MECKLENBURG COUNTY
Land Use & Environmental Services Agency

MEMORANDUM

Subject: Initial Rezoning Petition Comments

2020-125: Accent Homes Carolinas, Inc.

**RZ-1.0**

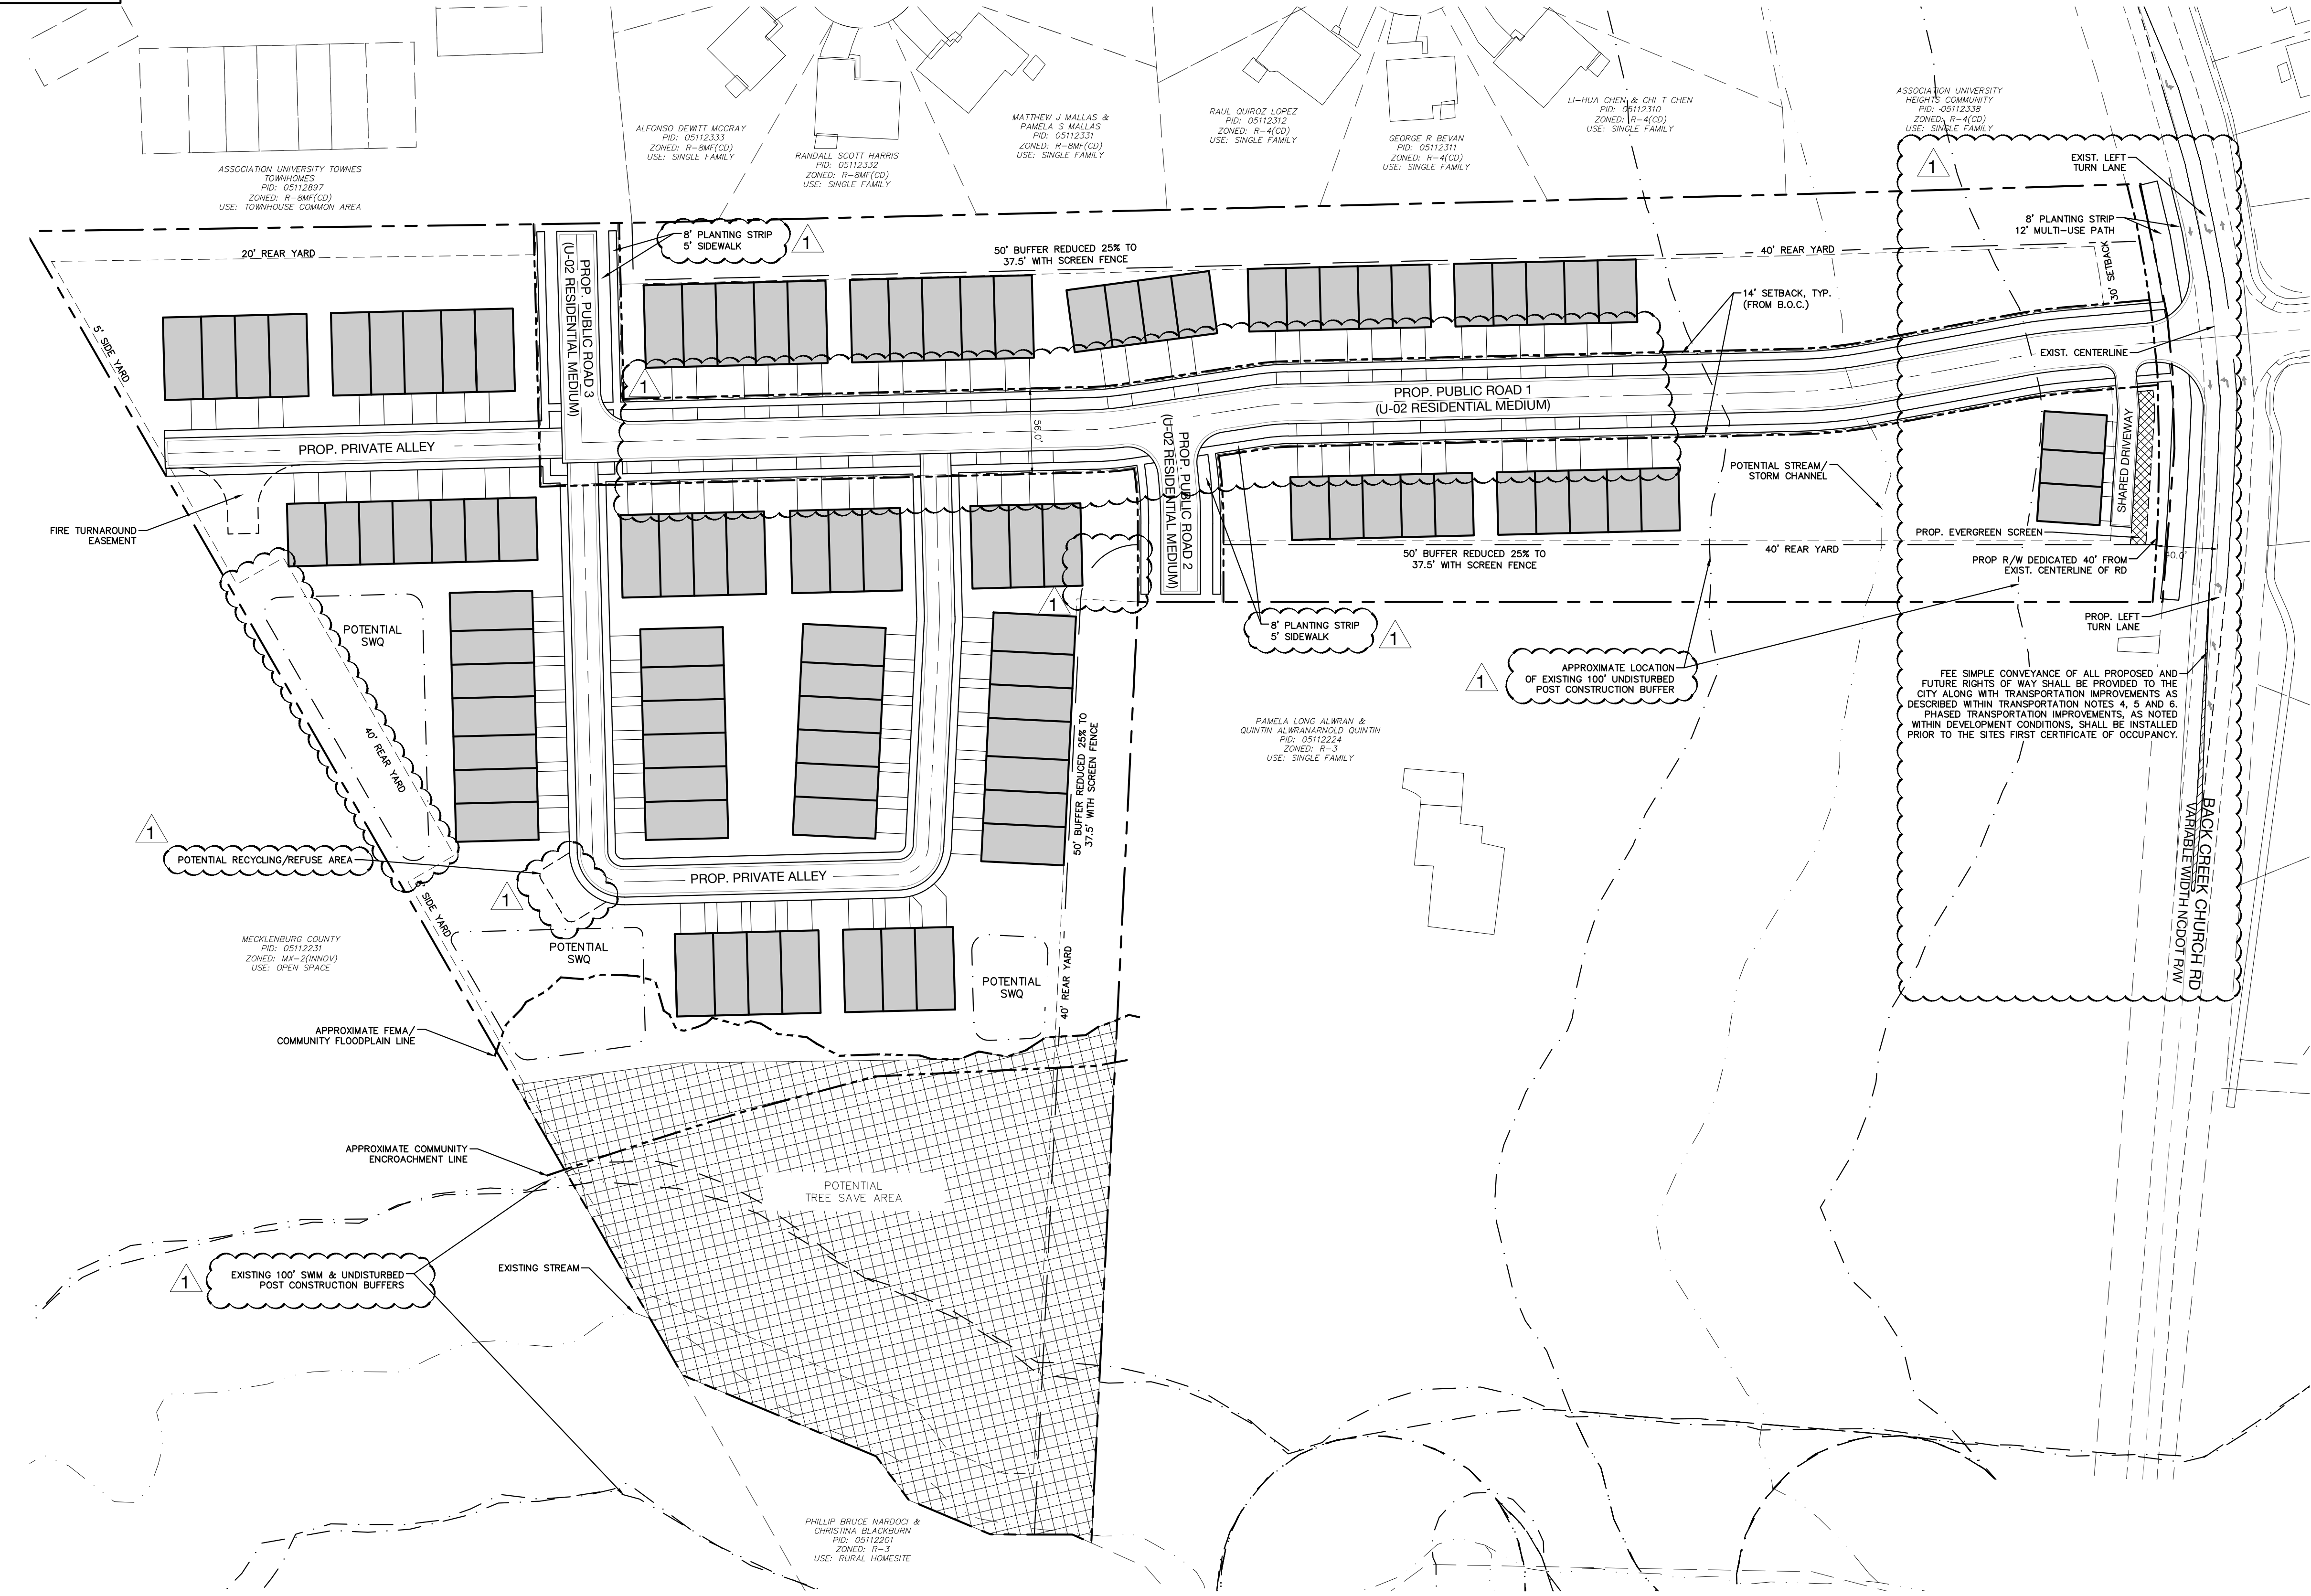
Storm Water Services Comments: A Floodplain Development permit must be obtained documenting compliance with the City of Charlotte Floodplain Regulations for all development occurring in the

floodplain. In addition, staff recommend any structures proposed within the Community Special Flood Hazard Area be constructed to a Flood Protection Elevation equal to the Community Base Flood Elevation plus two (2) feet of freeboard based upon recent analyses of the future floodplains supported by the Storm Water Advisory Committee.
